Application Ref:	3/2025/0827			 Ribble Valley Borough Council www.ribblevalley.gov.uk
Date Inspected:	19/1/26	Site Notice:	18/12/25	
Officer:	LH			
DELEGATED ITEM FILE REPORT:				REFUSAL

Development Description:	Erection of an agricultural storage barn, erection of 3 poles associated with the installation of CCTV and hardstanding (part-retrospective)
Site Address/Location:	Moor Game Hall Old Clitheroe Road Hurst Green PR3 2YU.

project name	project number	drawing number
moor game agricultural	23.46	Ex.02
name		
existing site plan		
scale	date	status
1 to 250 @ A1	august 23	planning
revision	C

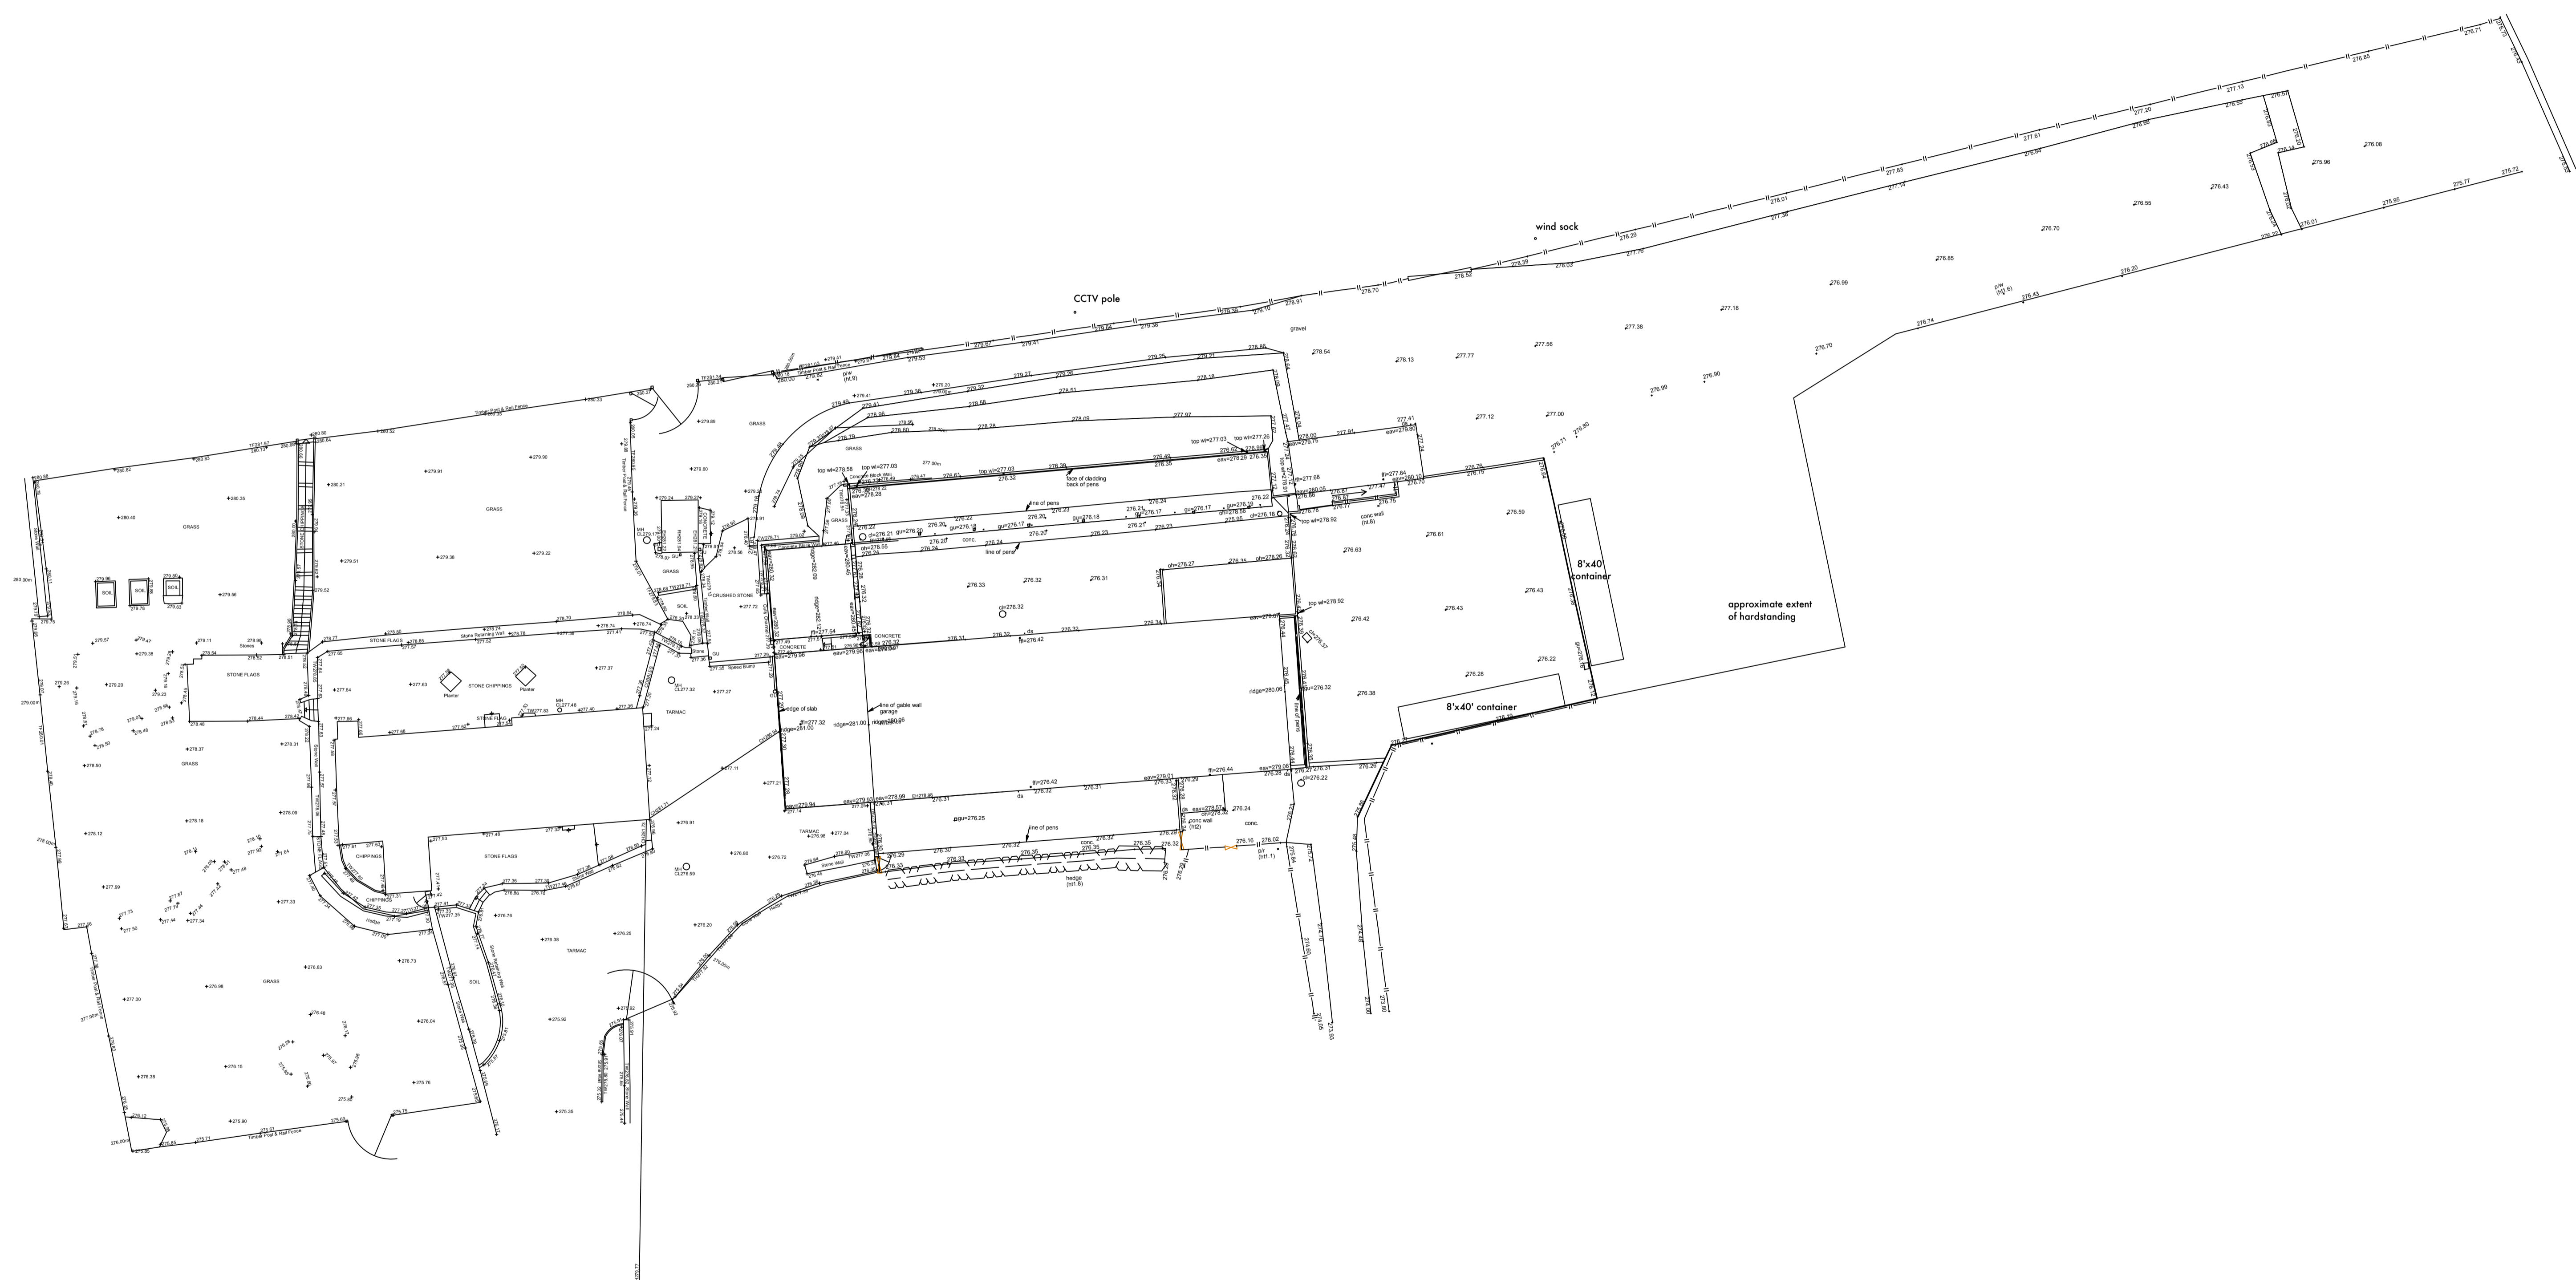
- Hardstanding – additional hardstanding has been laid to the east of the site extending towards the new agricultural storage barn and including an apron which is currently being used to site one of the shipping containers. The extent of new hardstanding is identified on submitted plan EX.02 Rev C and can be seen on site. This aspect is retrospective.

Natural England query the accuracy of the current site plan. This does reasonably accurately show the hardstanding proposed within the red edge of the application site. Whilst additional hardstanding outside of the red edge was evident on site, to the south of the proposed building and to the north, this falls outside the scope of the application.

PL.01

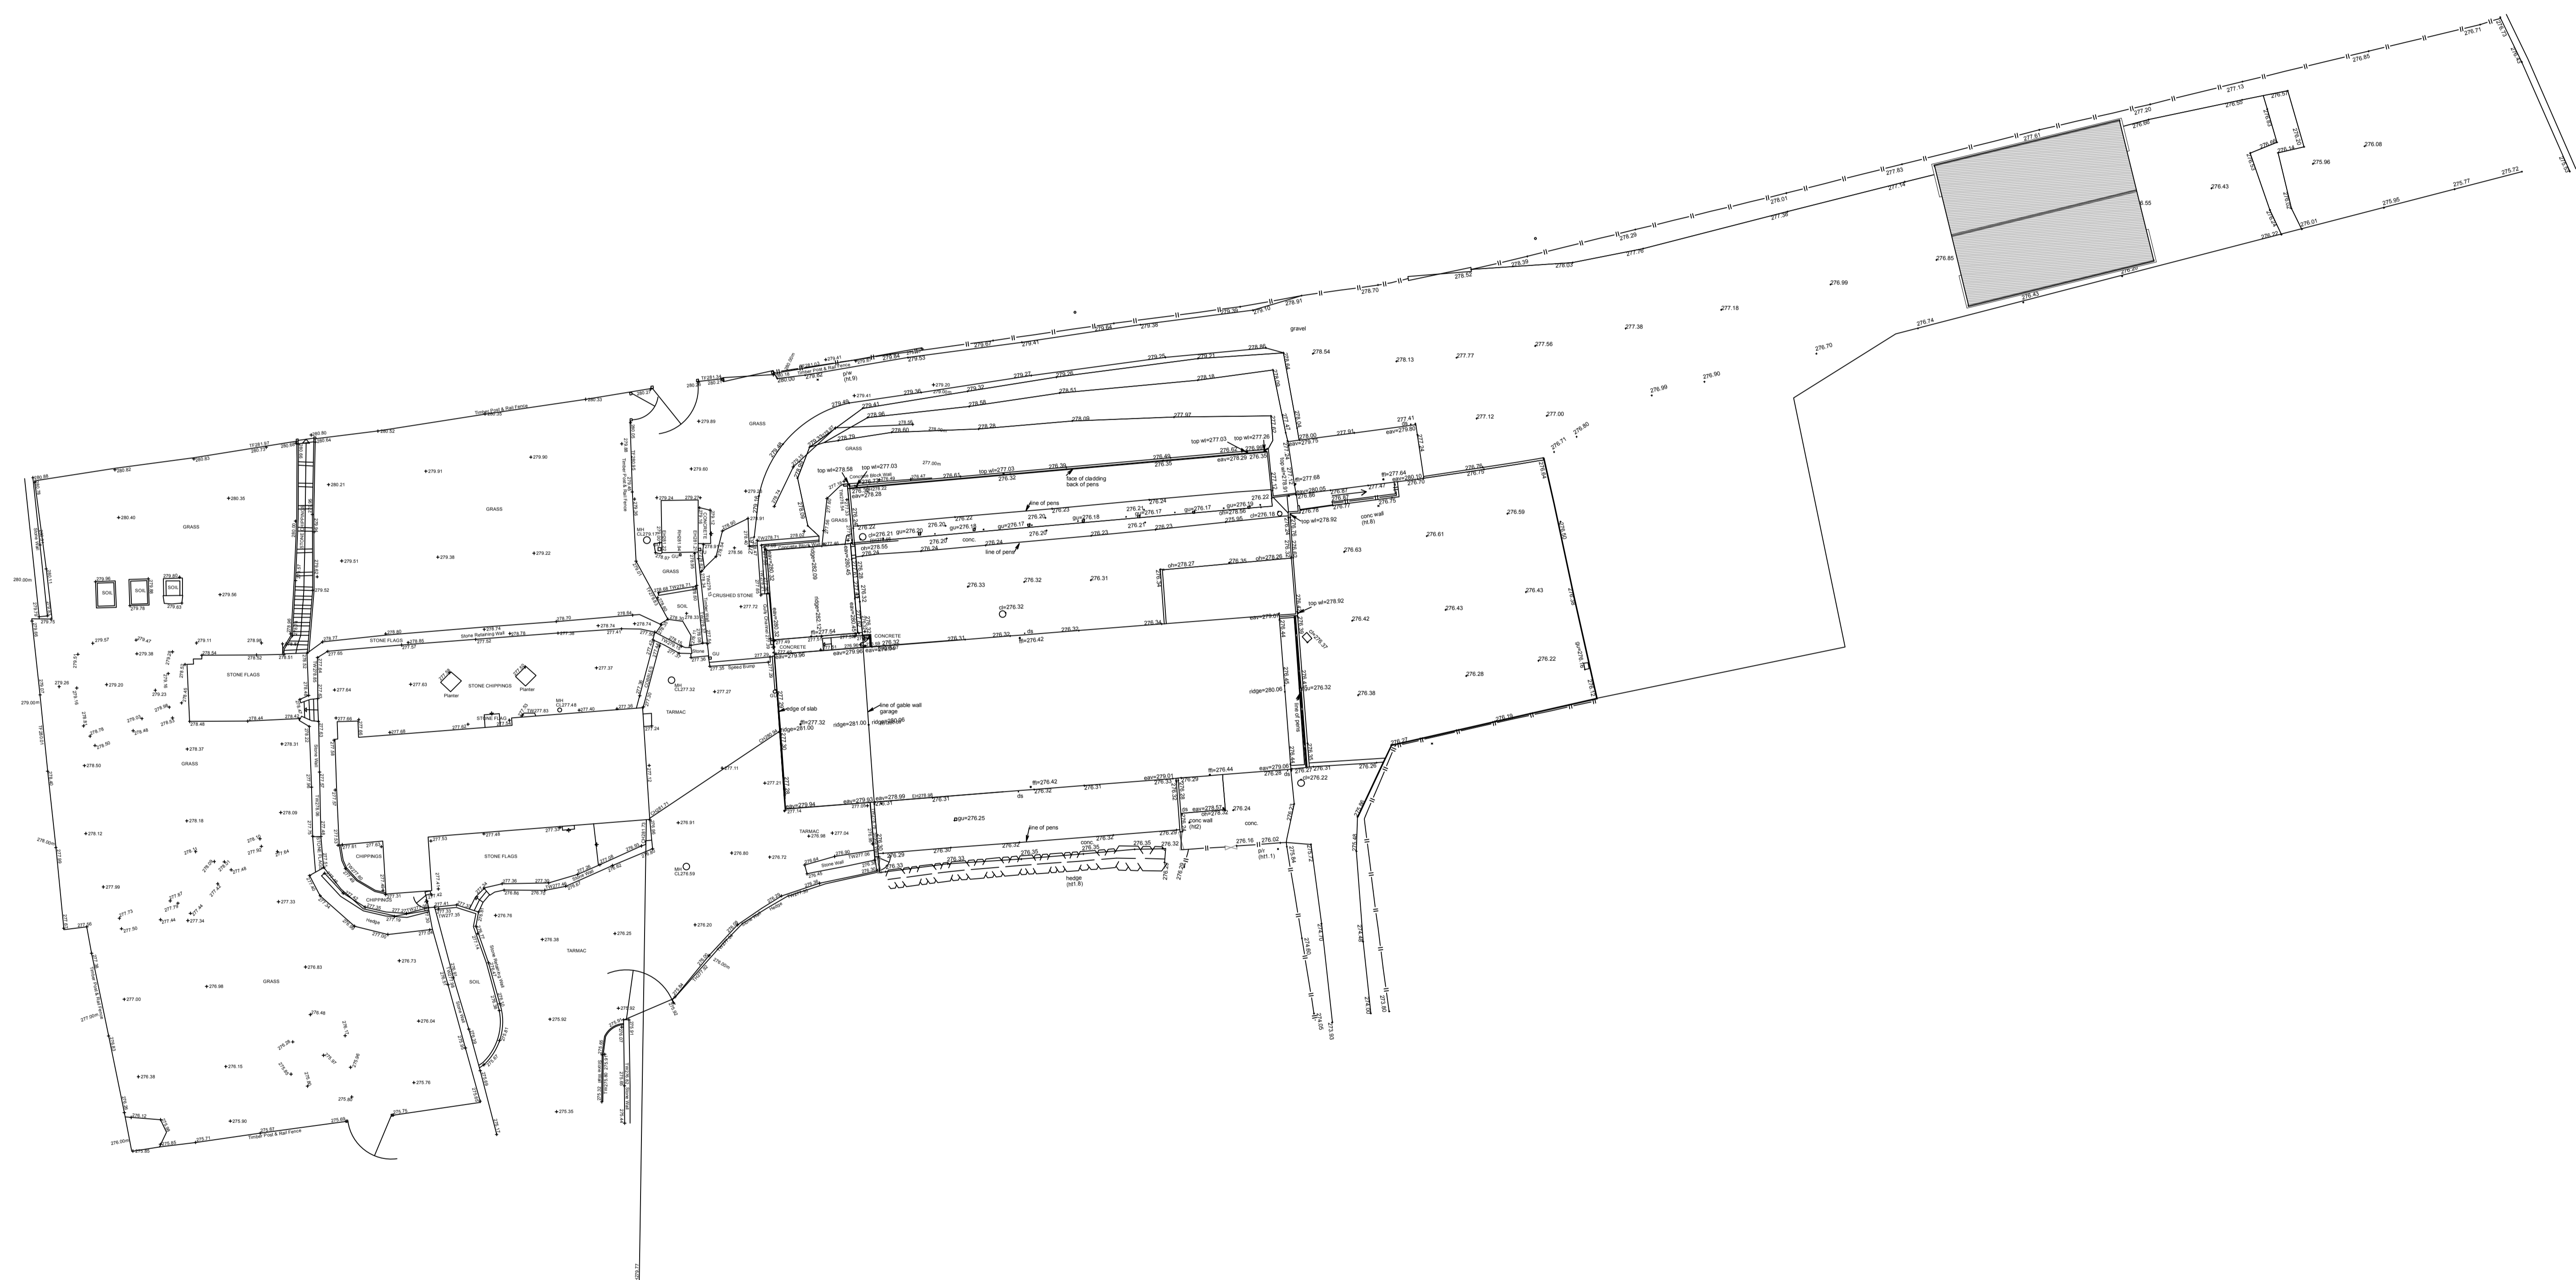
Even if there was an agricultural justification for a new building, there is no justification for its siting away from the current grouping of buildings including the extent of new hardstanding proposed.

Whilst the agricultural building is not excessive in scale, it would still be a sizeable addition to the site and its detached siting away from the existing group of buildings together with the proposed hardstanding means that it would fail to assimilate with the existing built form on site. Instead it would extend and elongate the built form into an undeveloped area of the site which, prior to the hardstanding being constructed, positively contributed to the open and rural character of the wider site and its setting within the national landscape.

Whilst the poles are a slimline design their height and siting (adjacent to the PROW in the case of 2 of the poles and elevated above existing buildings in the case of the third) does make them visually prominent. Whilst the poles along the PROW are sited adjacent to trees which helps to mitigate their visual impact their detachment from the built form on site makes them an incongruous feature in the landscape.
